Roads and Maritime Reference: SYD16/00527/03 (A18618599)
DP&E Ref: SSD7610

RESPONSE TO SUBMISSIONS FOR ALTERATIONS AND ADDITIONS INNER SYDNEY HIGH
SCHOOL SURRY HILLS

Roads and Maritime has reviewed the Response to Submissions and provides further comments at **Attachment A** for DP&E's consideration in the determination of the application. Further to these comments, Roads and Maritime would grant its concurrence to the driveway adjustment works on Cleveland Street under Section 138 of the *Roads Act, 1993* subject to the following conditions being included in any consent issued by DP&E:

- SECTION (WITH CONCRETE KERB)**
1:20

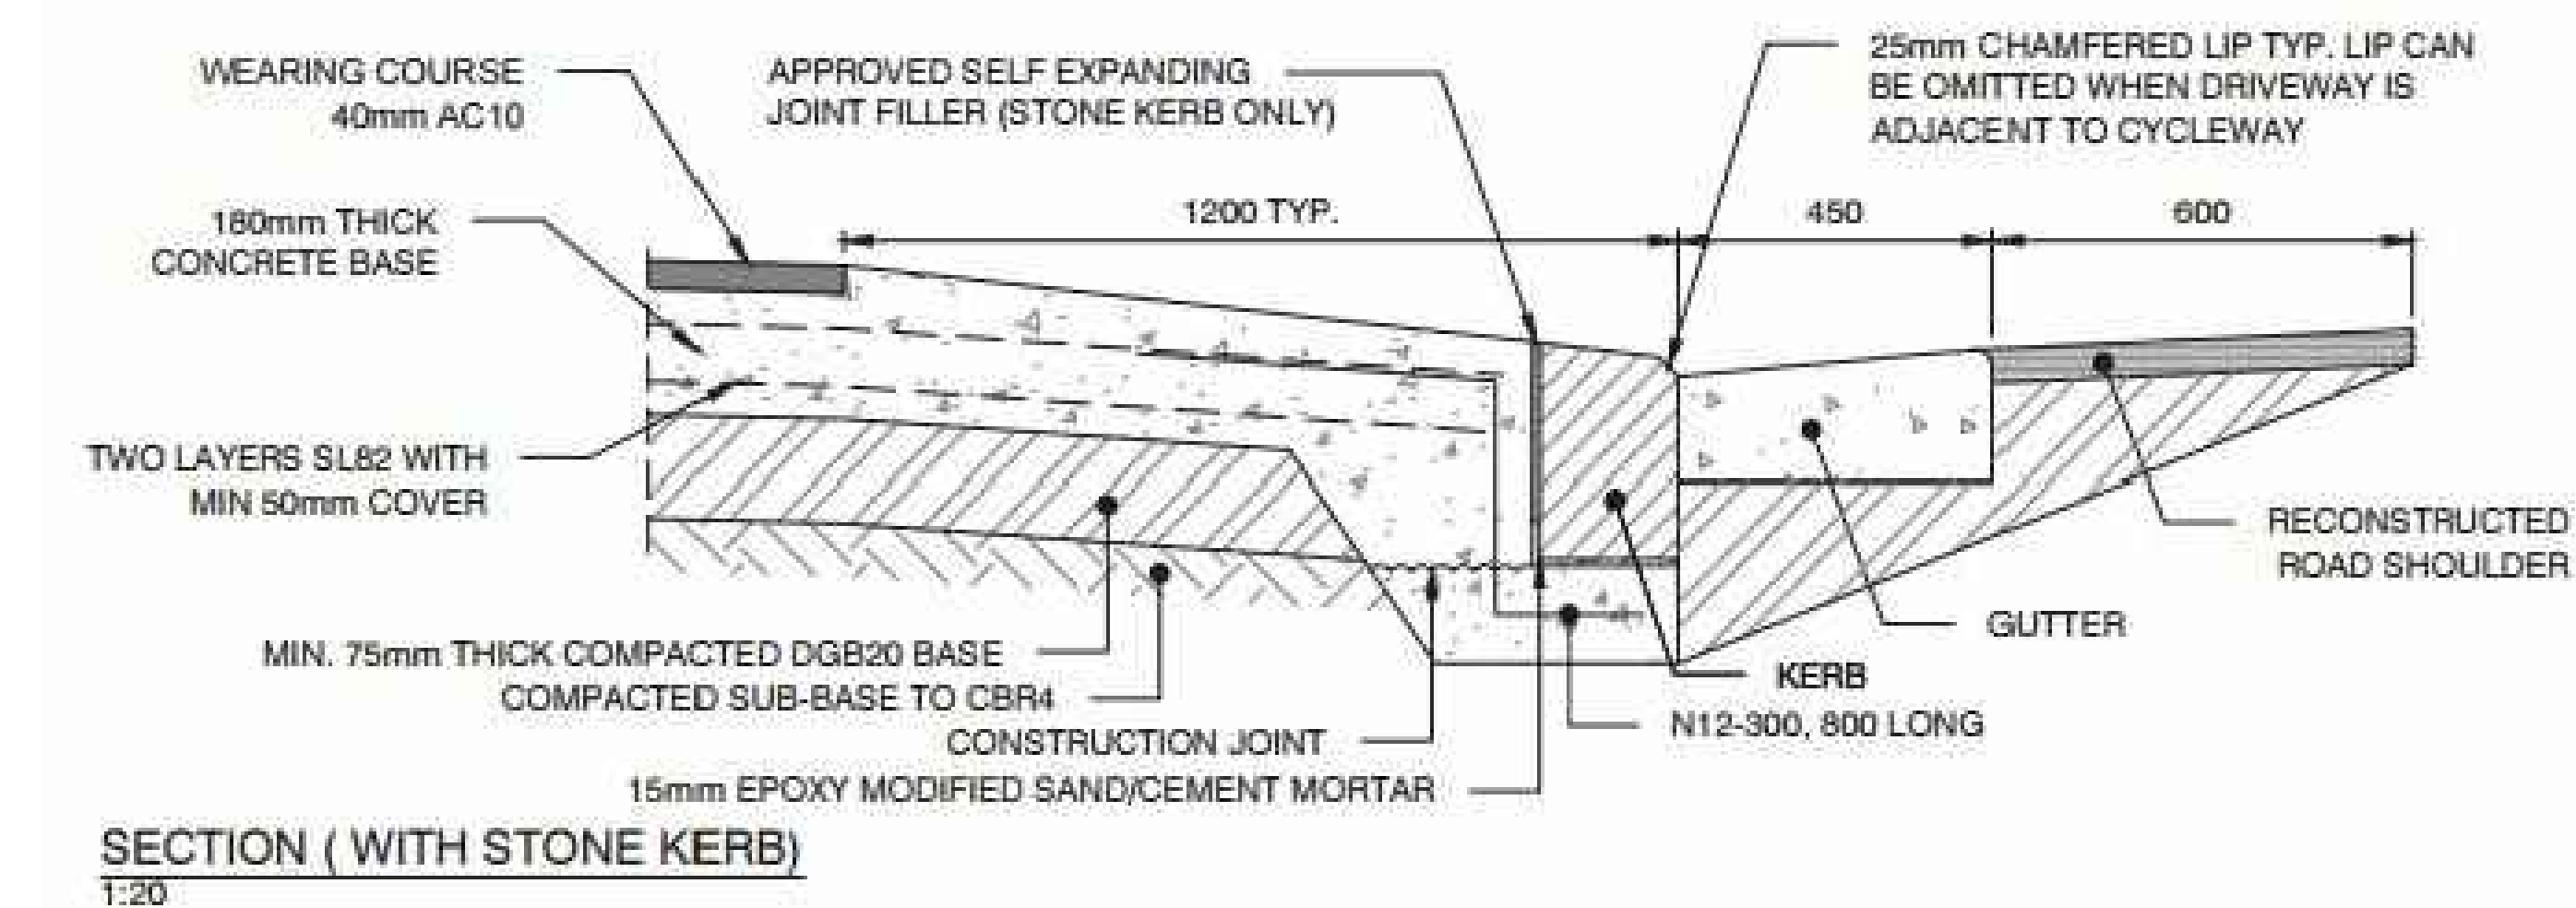
1. All buildings and structures, together with any improvements integral to the future use of the site are to be wholly within the freehold property (unlimited in height or depth), along the Cleveland Street boundary.
2. The design and construction of the gutter crossing on Cleveland Street shall be in accordance with Roads and Maritime requirements. Details of these requirements should be obtained from Roads and Maritime Services, Manager Developer Works, Statewide Delivery, Parramatta (telephone 9598 7798).

Detailed design plans of the proposed gutter crossing are to be submitted to Roads and Maritime for approval prior to the issue of a Construction Certificate and commencement of any road works.
